Recommendation Report for Planning Permission for Works or Extension to a Dwelling

REF NO: **AW/131/15/HH**

LOCATION: 16 Rossalyn Close
Pagham

PROPOSAL: Two storey side extension with single storey element (resubmission following AW/60/15/HH).

sheet 1 a of 3

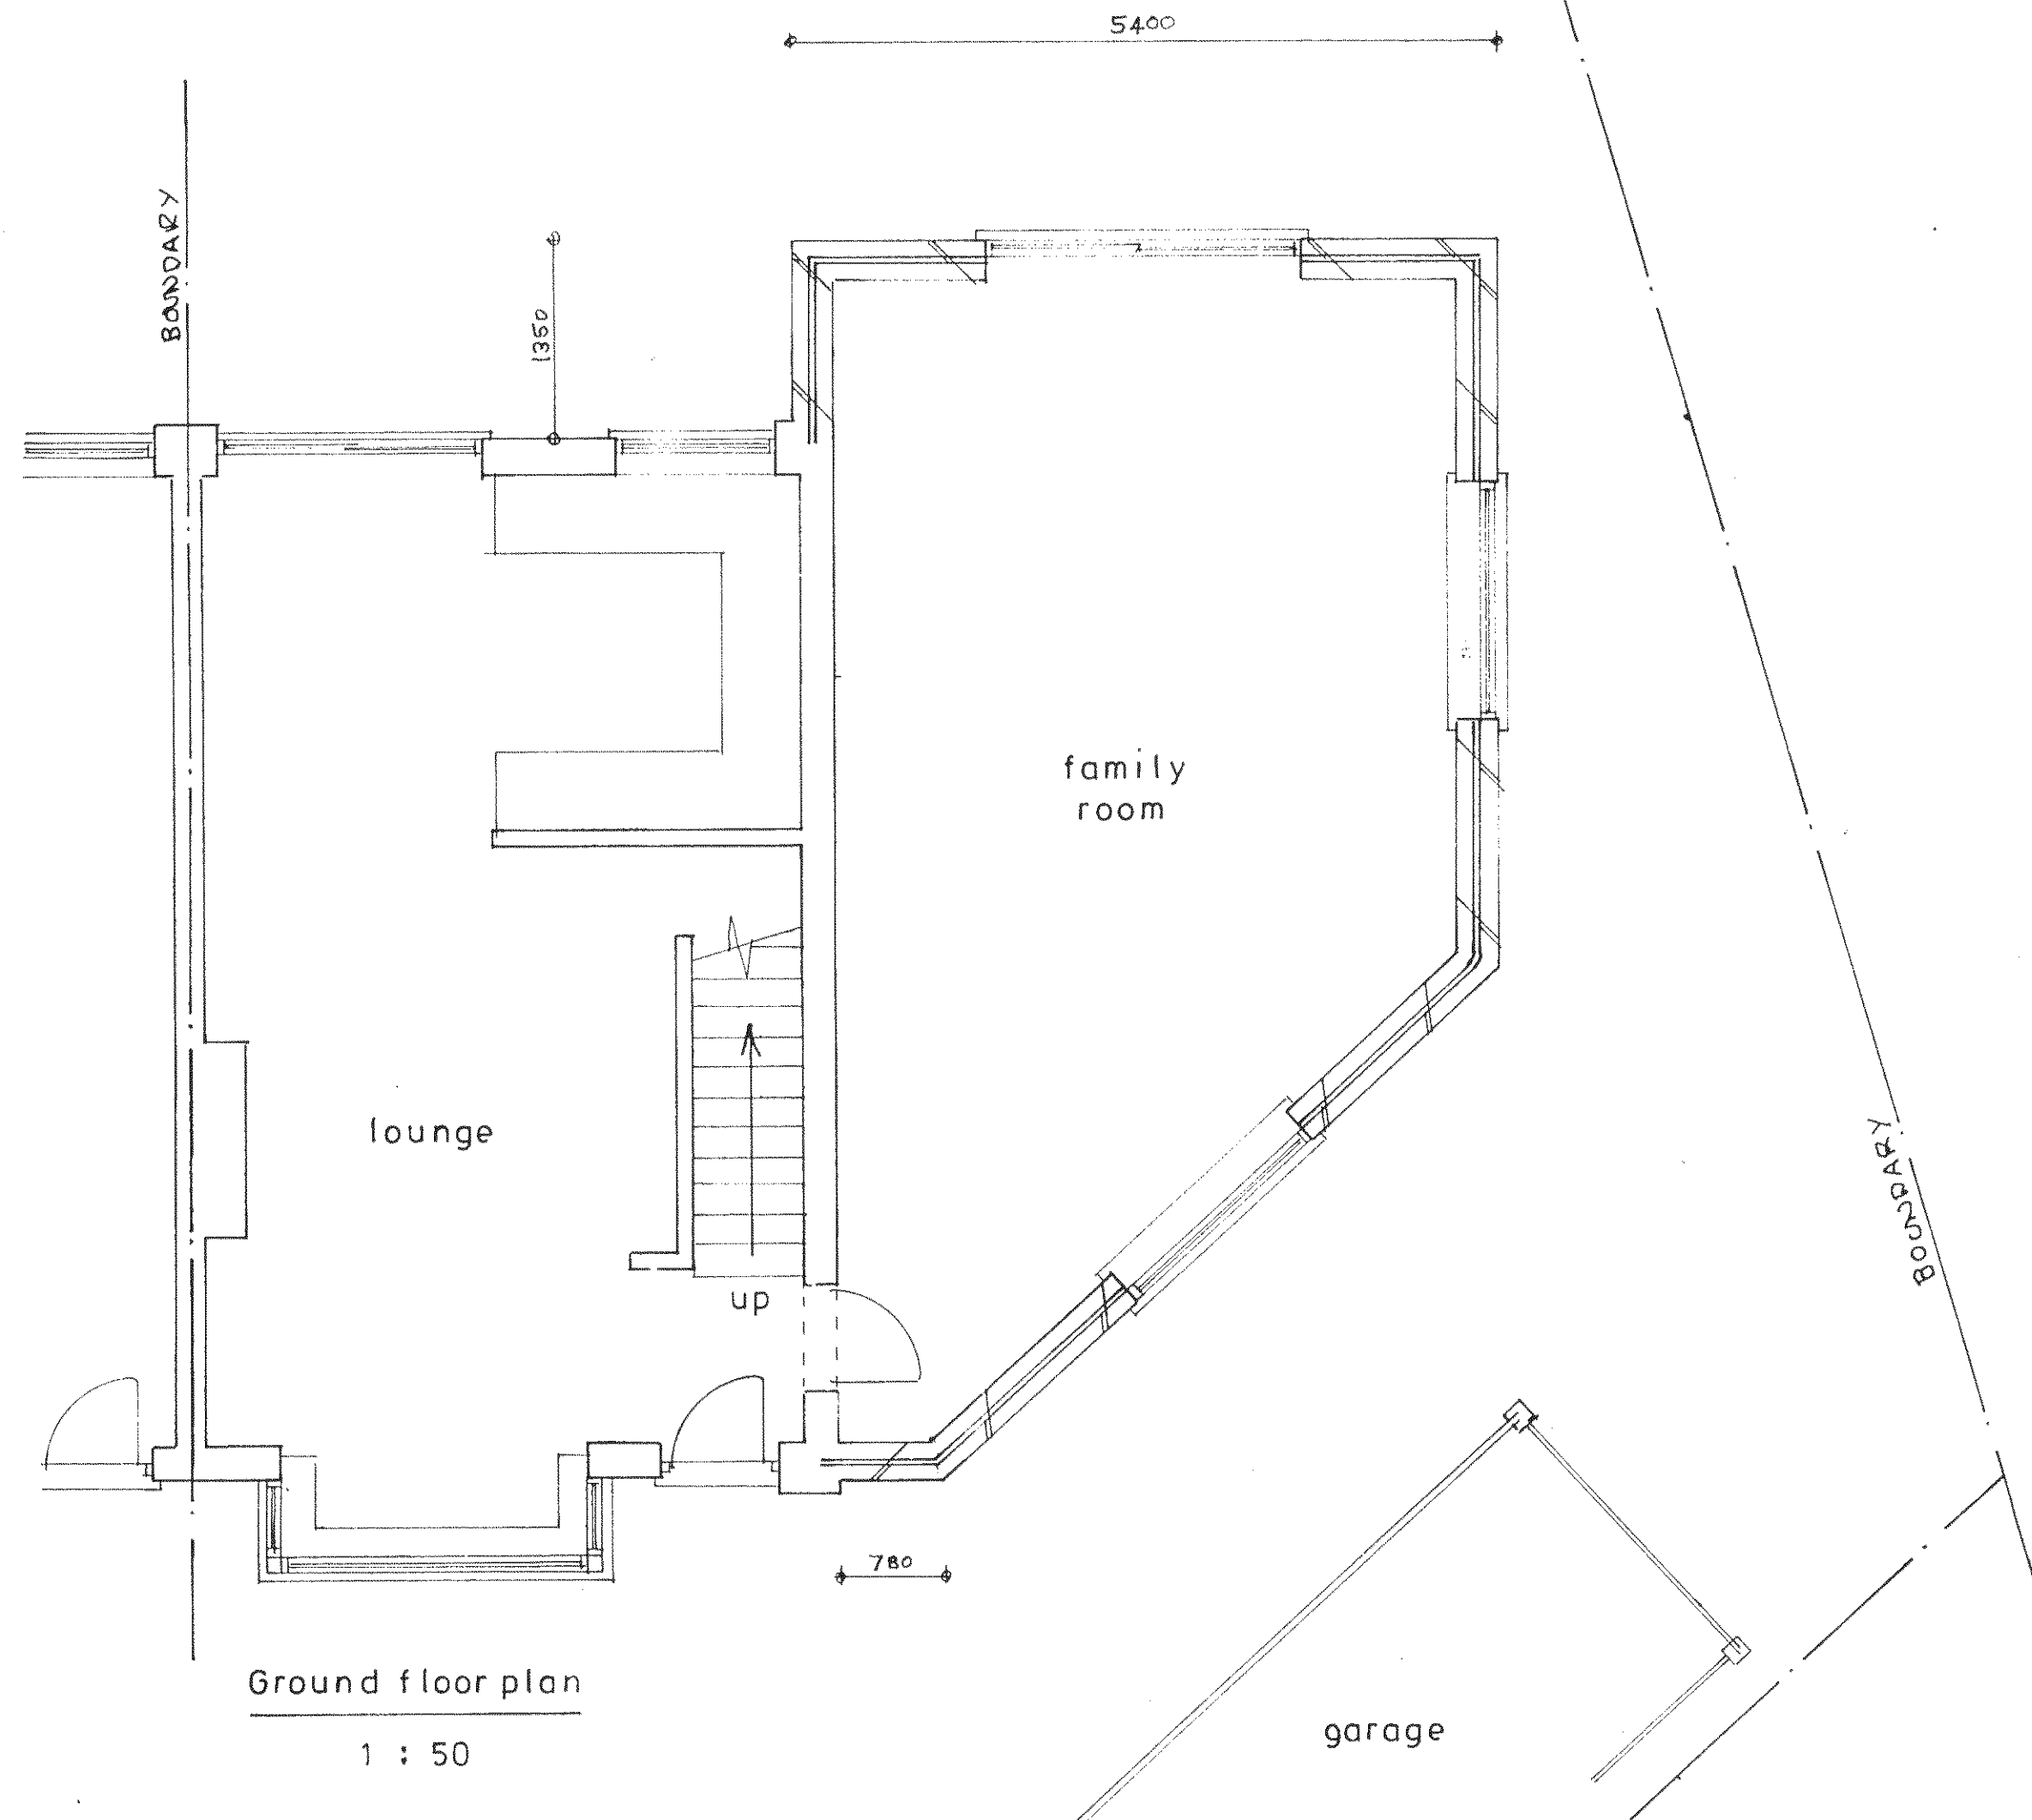
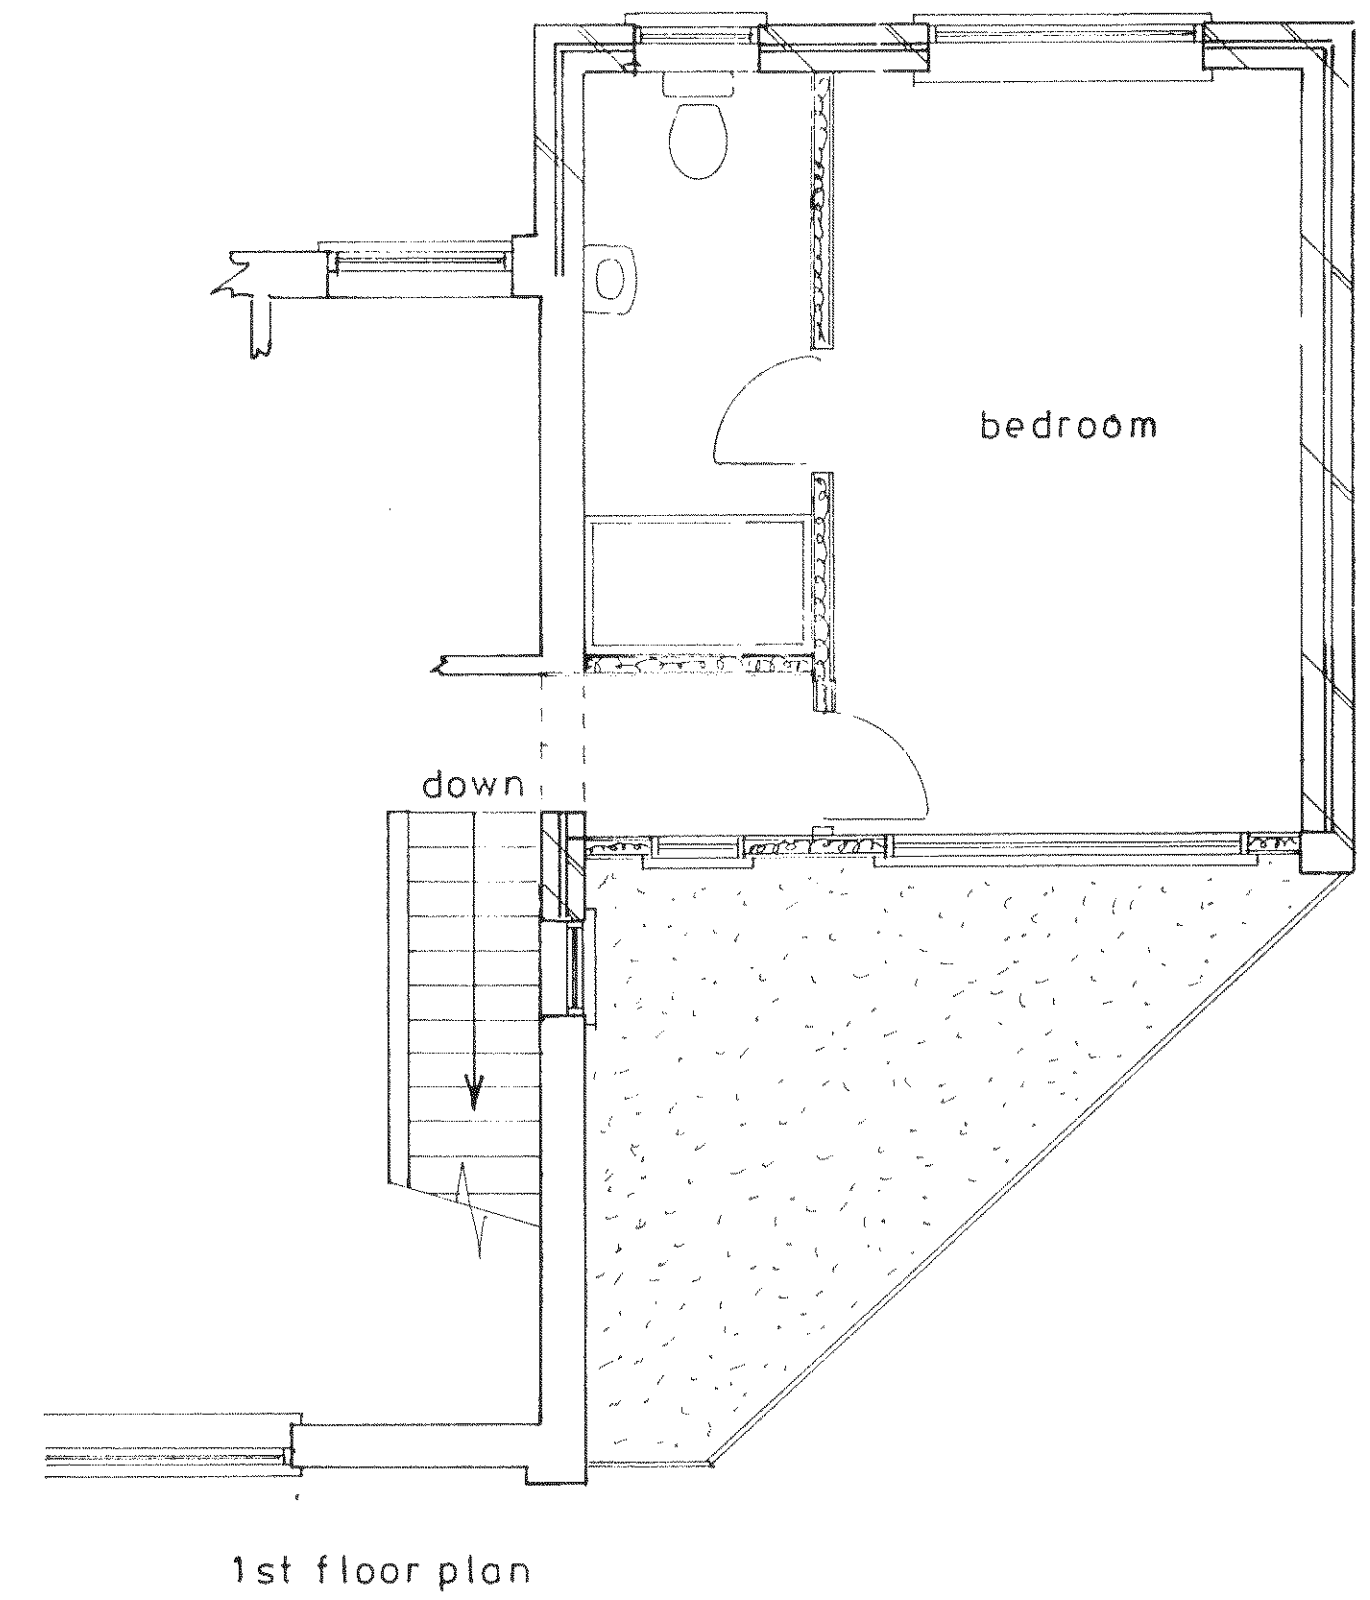
The extended dwelling will retain at least 3 car spaces and as such the development accords with parking standards for 4-4 bedroom dwellings. The family room, bedroom and en-suite to be provided have floor areas in excess of the required space standards.

sheet 2 a of 3

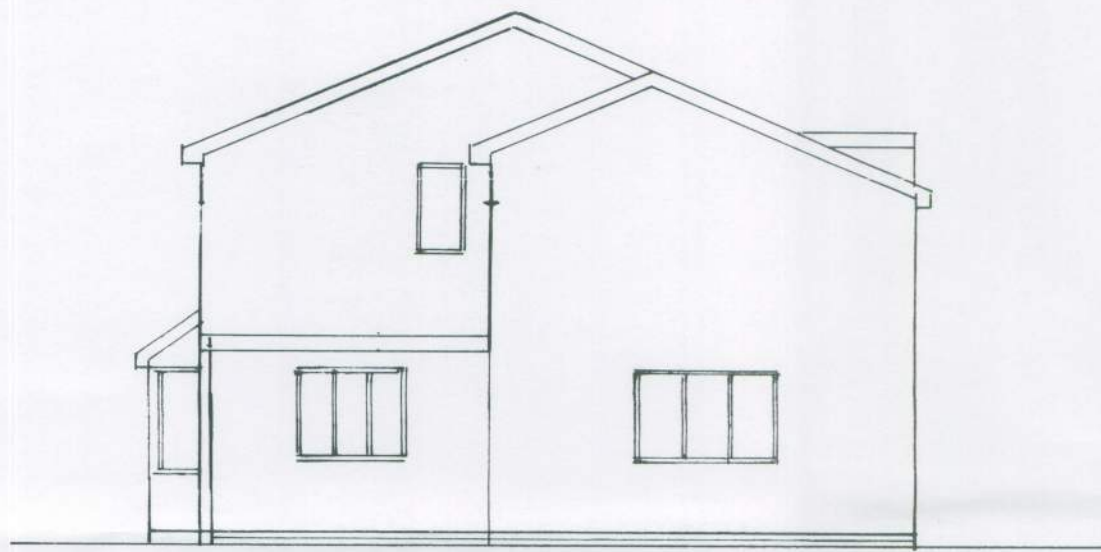
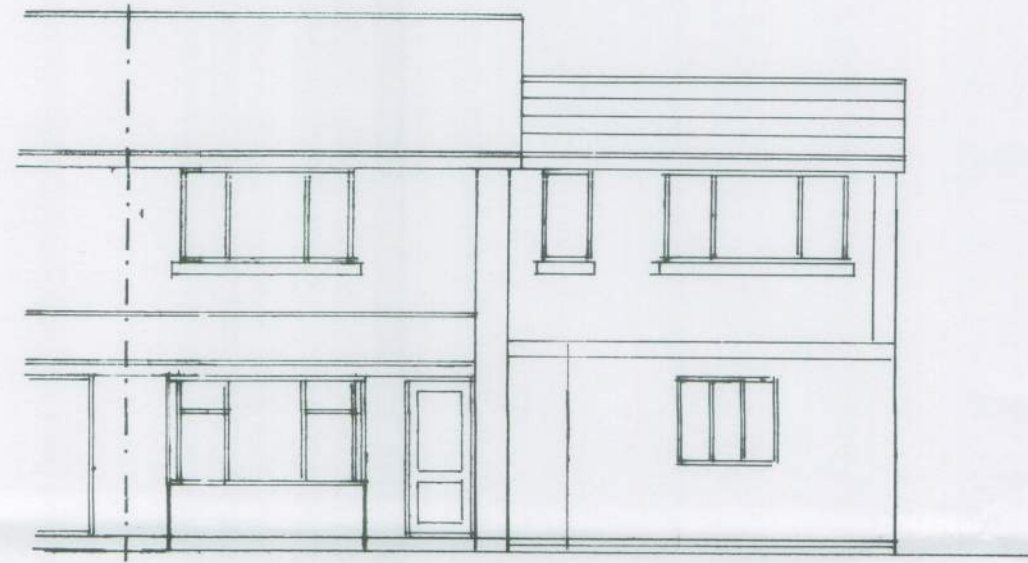
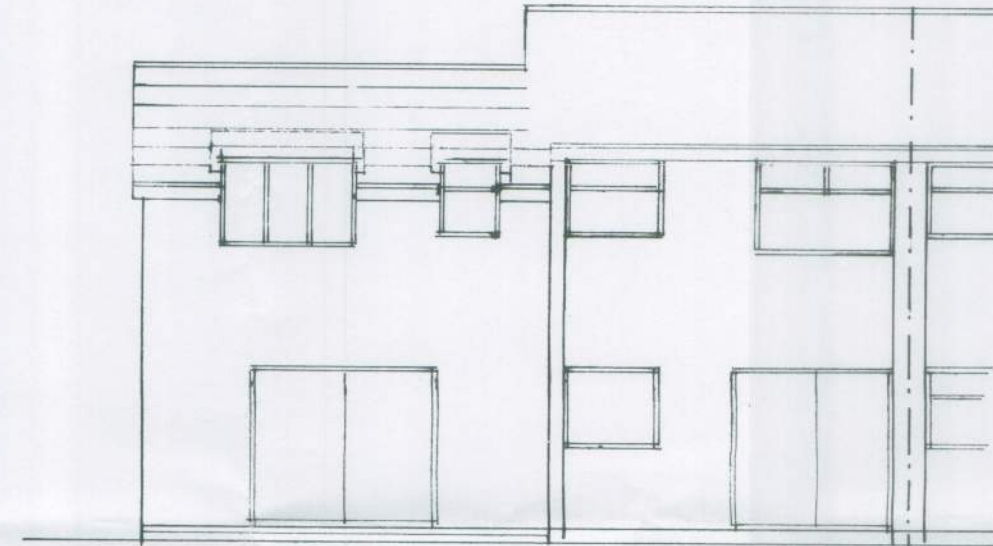
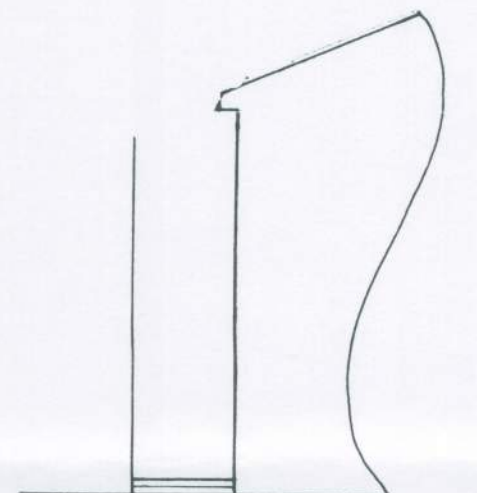
The design of the extension now also includes windows which reflect the proportions of existing windows and which lend the extension a more satisfactory appearance and not to be detrimental to the appearance of the existing dwelling.

The proposed main roof is now of a more traditional design and reflects the appearance of the existing dwelling. The flat roof to the front single storey element is required due to its irregular shape and will have a very limited visual impact. The location of the extension is not widely visible.
